Norfolk Boreas Offshore Wind Farm Technical Note Revised Cawston Highway Intervention Scheme

Applicant: Norfolk Boreas Limited
Document Reference: ExA.AS-2.D4.V1
Deadline 4

Date: January 2020
Revision: Version 1
Author: Royal HaskoningDHV

13 APPENDIX 6 SCHEME OF HIGHWAY MITIGATION (B1145, CAWSTON)

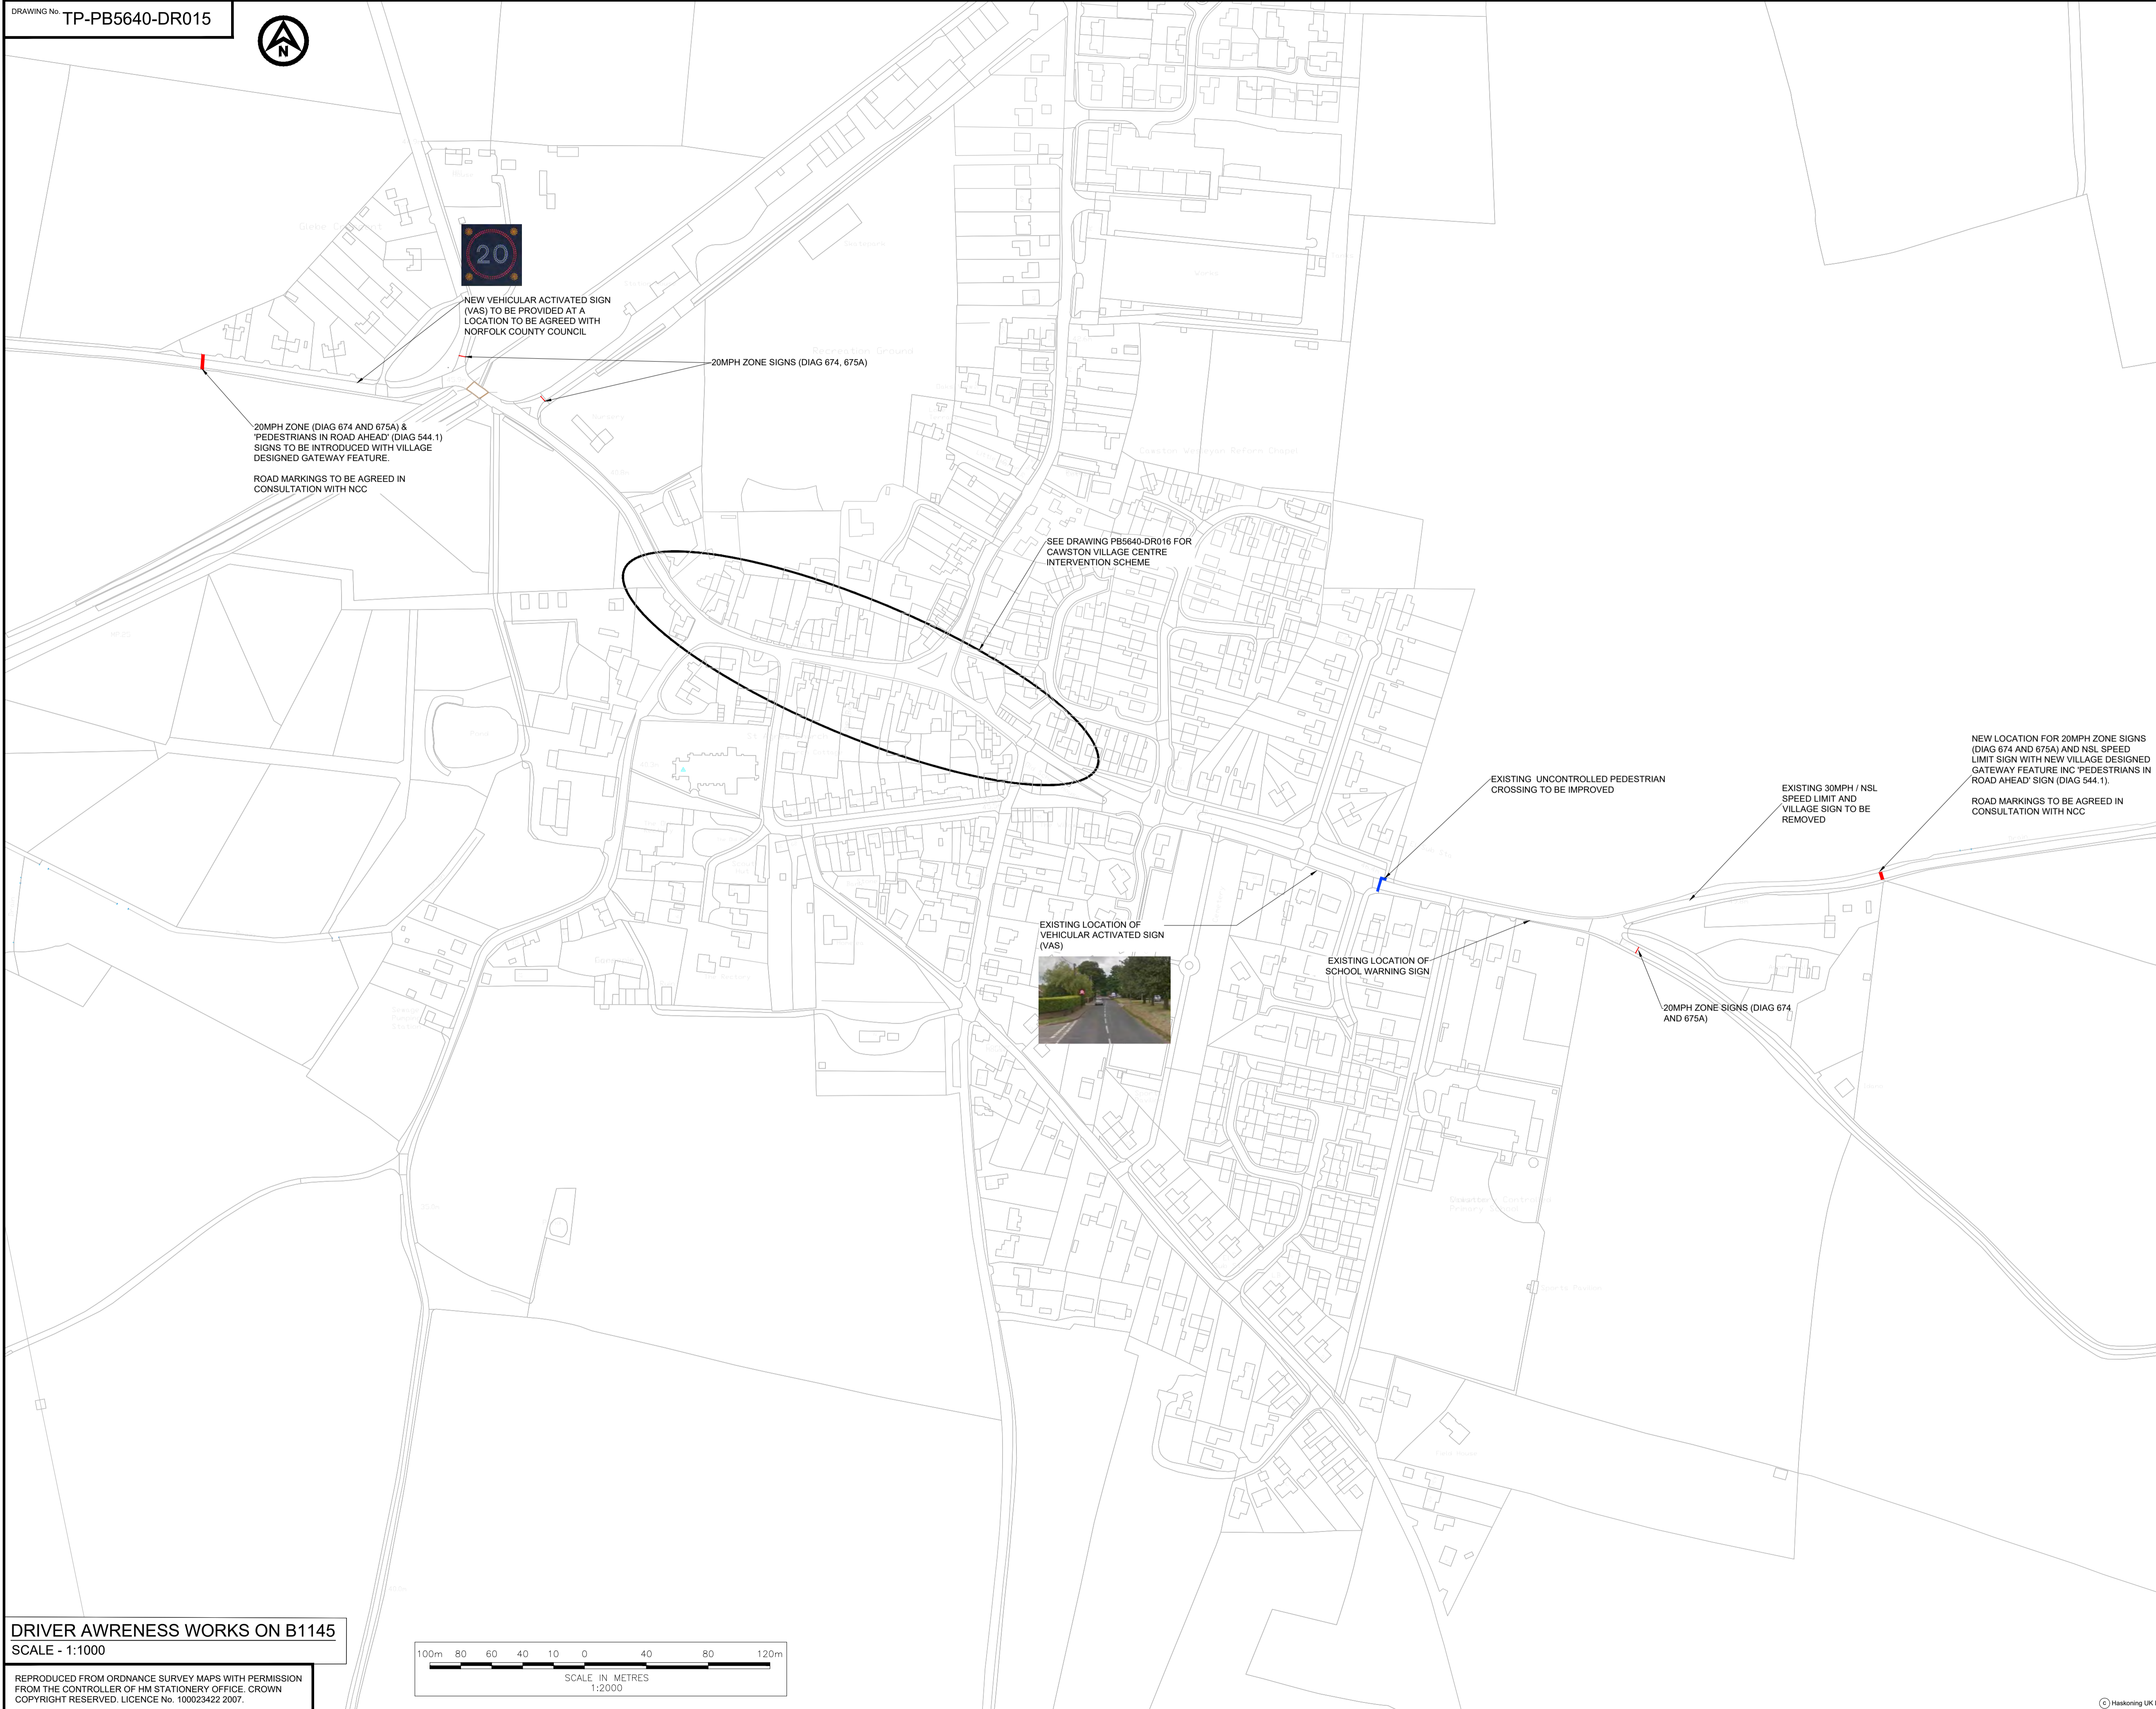
26. The 20mph Zone signing has been updated to ensure all 'gateways' into the designated areas are clearly signed and therefore all roads within the 20mph zone are enforceable.

CAWSTON VILLAGE CENTRE - B1145
SCALE - 1:500

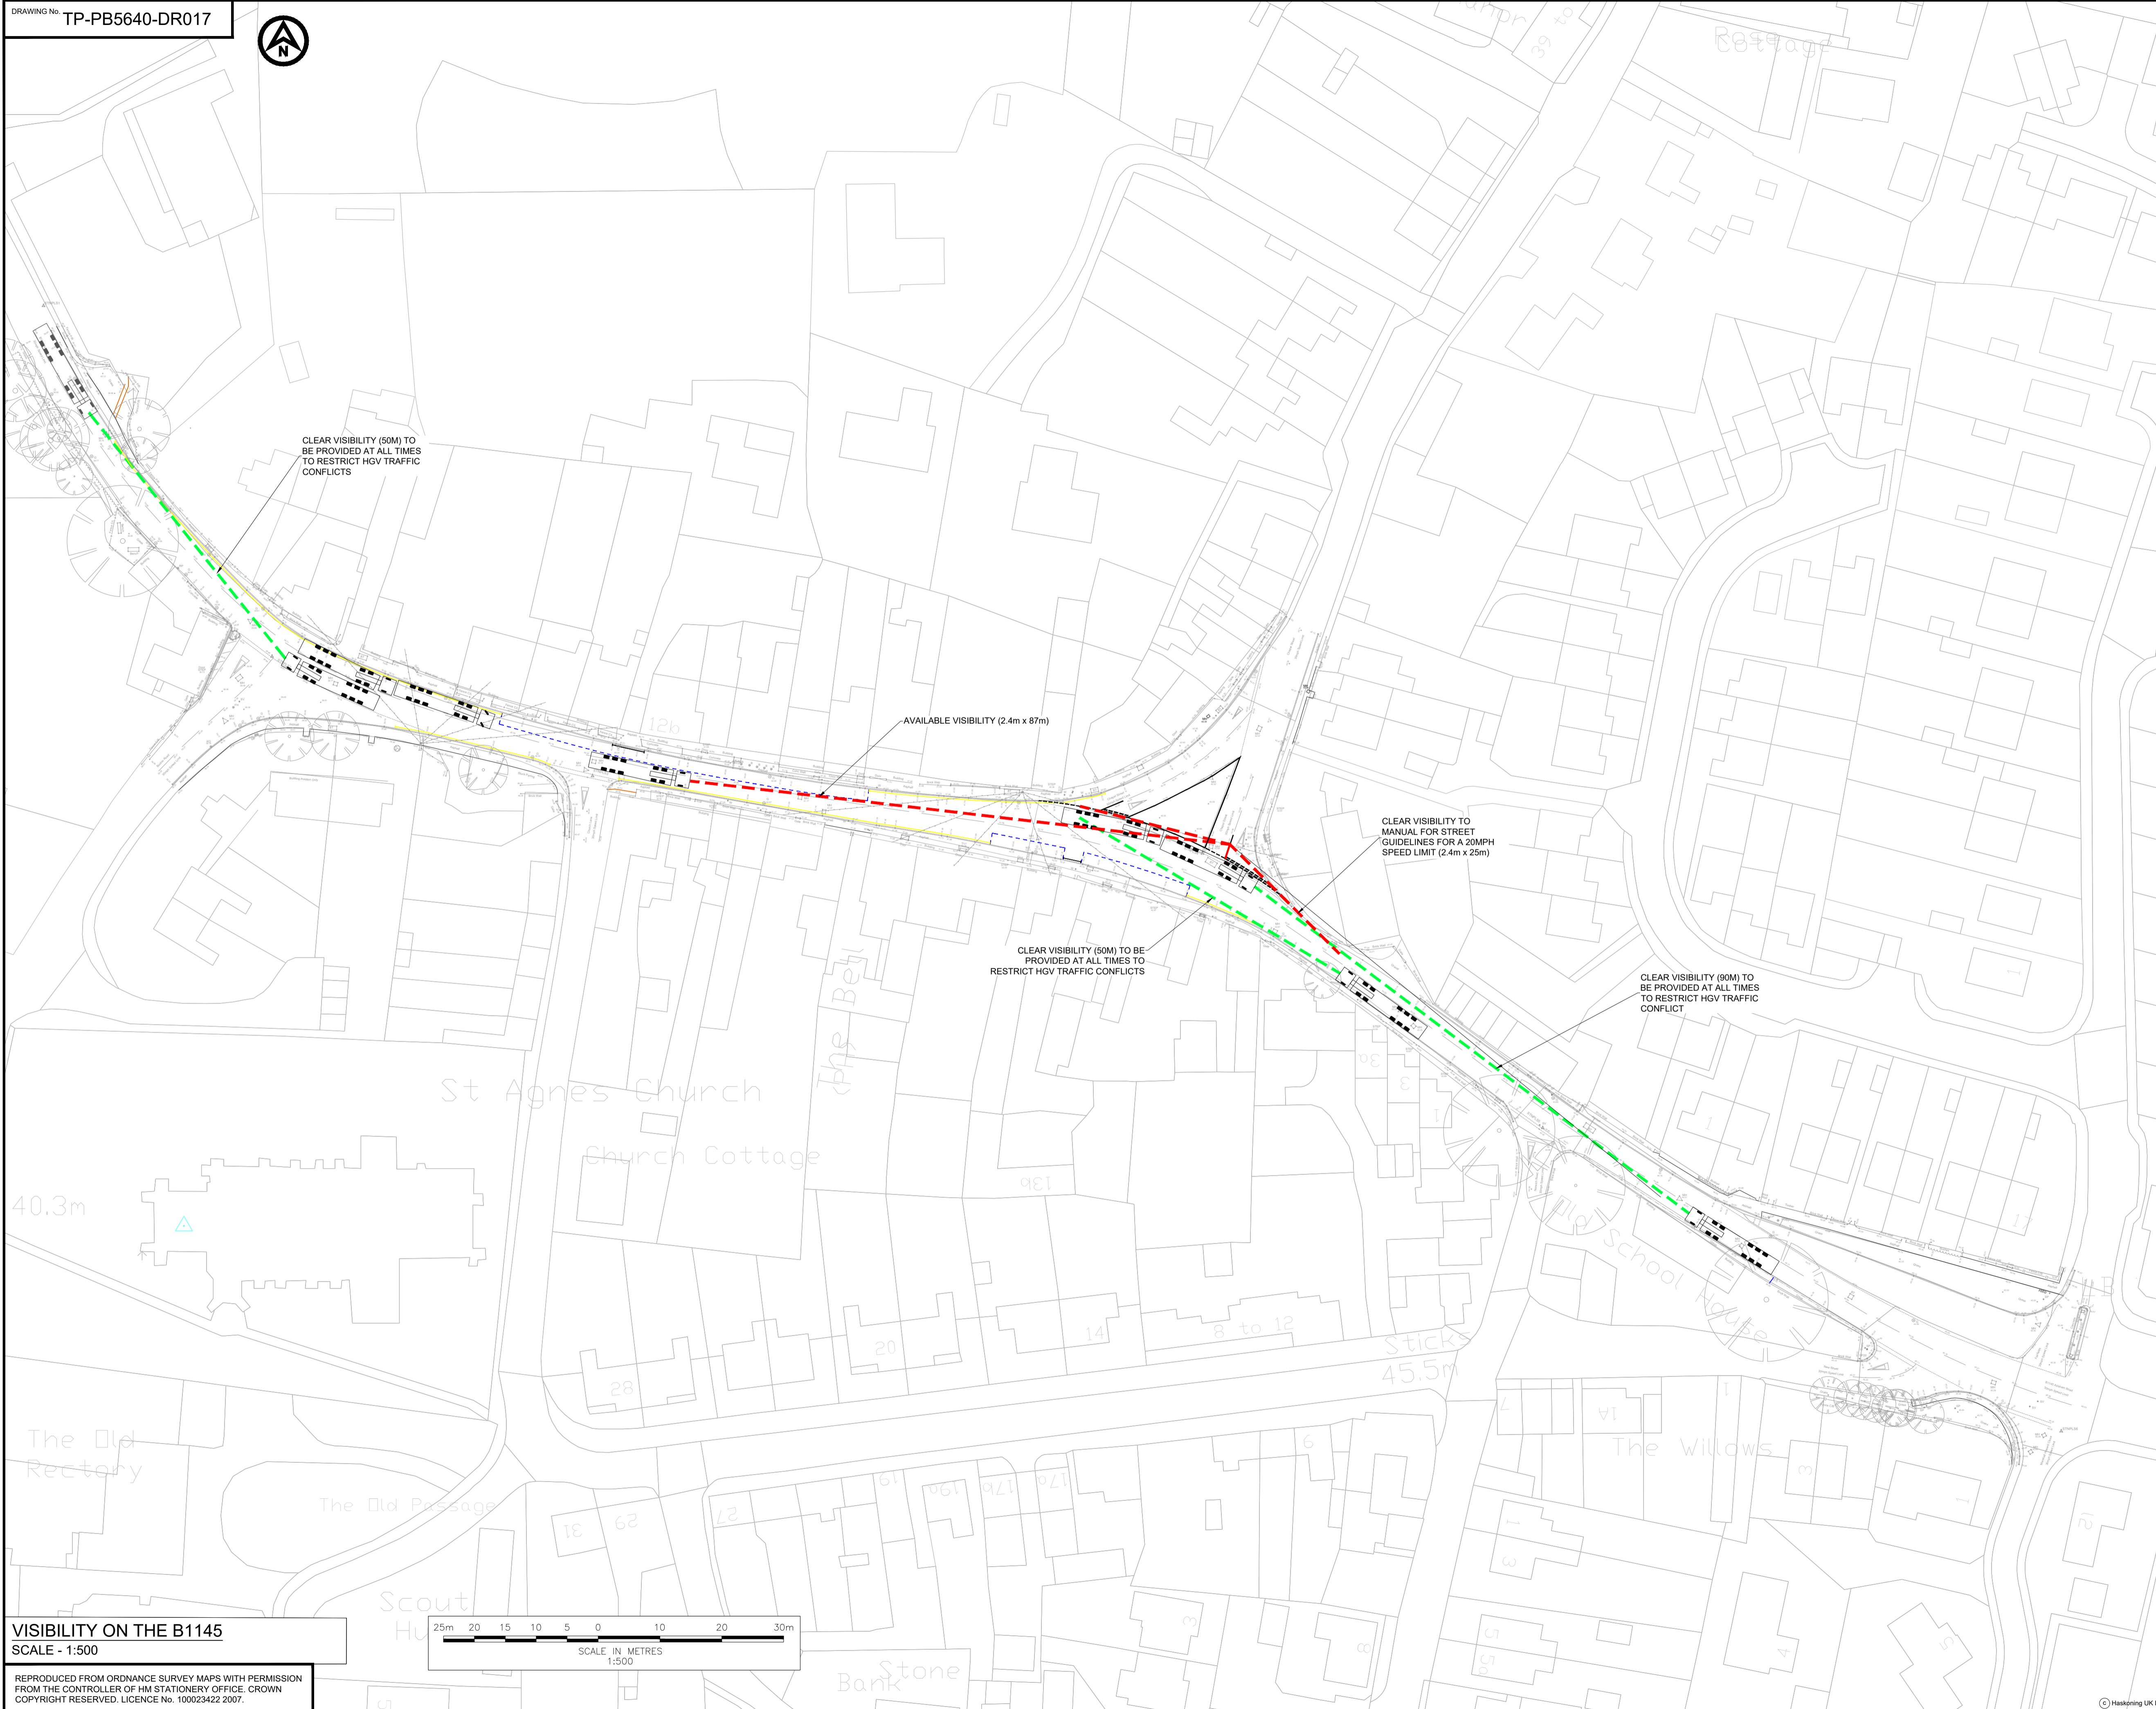
15. A review of the topographical data provided by Hornsea Project Three revealed a narrower road carriageway than on the OS mapping used for the original scheme. As such the footpath widening cannot be accommodated and is to be removed.
16. Concerns have been raised with regards to the impact on pedestrian amenity from the removal of the proposed footpath widening. However, providing adequate road space and introducing the mandatory 20mph speed limit will reduce the likelihood of a pedestrian and vehicle conflict and therefore will mitigate the pedestrian amenity impact. It is also considered that at the narrowest points of the footpath protection is afforded by parked vehicles.

22. The kerbside parking surveys indicate the maximum demand for parking on the north side of High Street was nine vehicles. The Applicant has used this information to reallocate road space. The parking provision on the north side of High Street has been reduced to nine spaces from the 12 spaces detailed in the HIS. This provides more road space at the western end of High Street to facilitate additional vehicle stacking and therefore reduce the probability of HGV's 'backing up' and blocking through traffic. In addition, it is proposed to add an additional bay on the south side of High Street outside the Café increasing the total provision from four bays to five.

23. To promote efficient use of kerbside parking, it is proposed not to mark out individual vehicle parking bays but to just denote the entire parking area with a broken line box (similar to the approach adopted UK wide for resident parking schemes). It is felt this approach will allow residents to self-manage and ensure the most efficient use of the available parking. The situation will be monitored and if necessary, individual bay markings could be introduced at a later stage.

24. Finally, to enforce the parking arrangements it is proposed to implement a limited waiting traffic regulation order to ensure that indiscriminate parking does not occur during construction delivery times. This entails the making of a 'Limited Waiting' order that will prevent on-street parking, on the High Street, outside of the designated parking areas for the period between 9am and 6pm, Monday to Friday. The time slot has been selected as a balance to protect residents parking amenity but to also afford enough time for deliveries to ensure the construction works can progress in a timely manner.
25. The Limited Waiting order will be denoted on street by the presence of a single yellow line supplemented by a small plate indicating the (time) limit of the restriction. The location of the plates has been carefully chosen so as to not restrict the available footway width.

30. It is proposed to widen the carriageway on the north side of High Street adjacent to Chapel Street, removing approximately one metre of the triangular parking area.

This will provide extra space for HGVs to pass and promote clean sight lines for eastbound drivers. This proposal will not compromise the parking capacity of the triangular parking area, which will retain capacity for five vehicles.
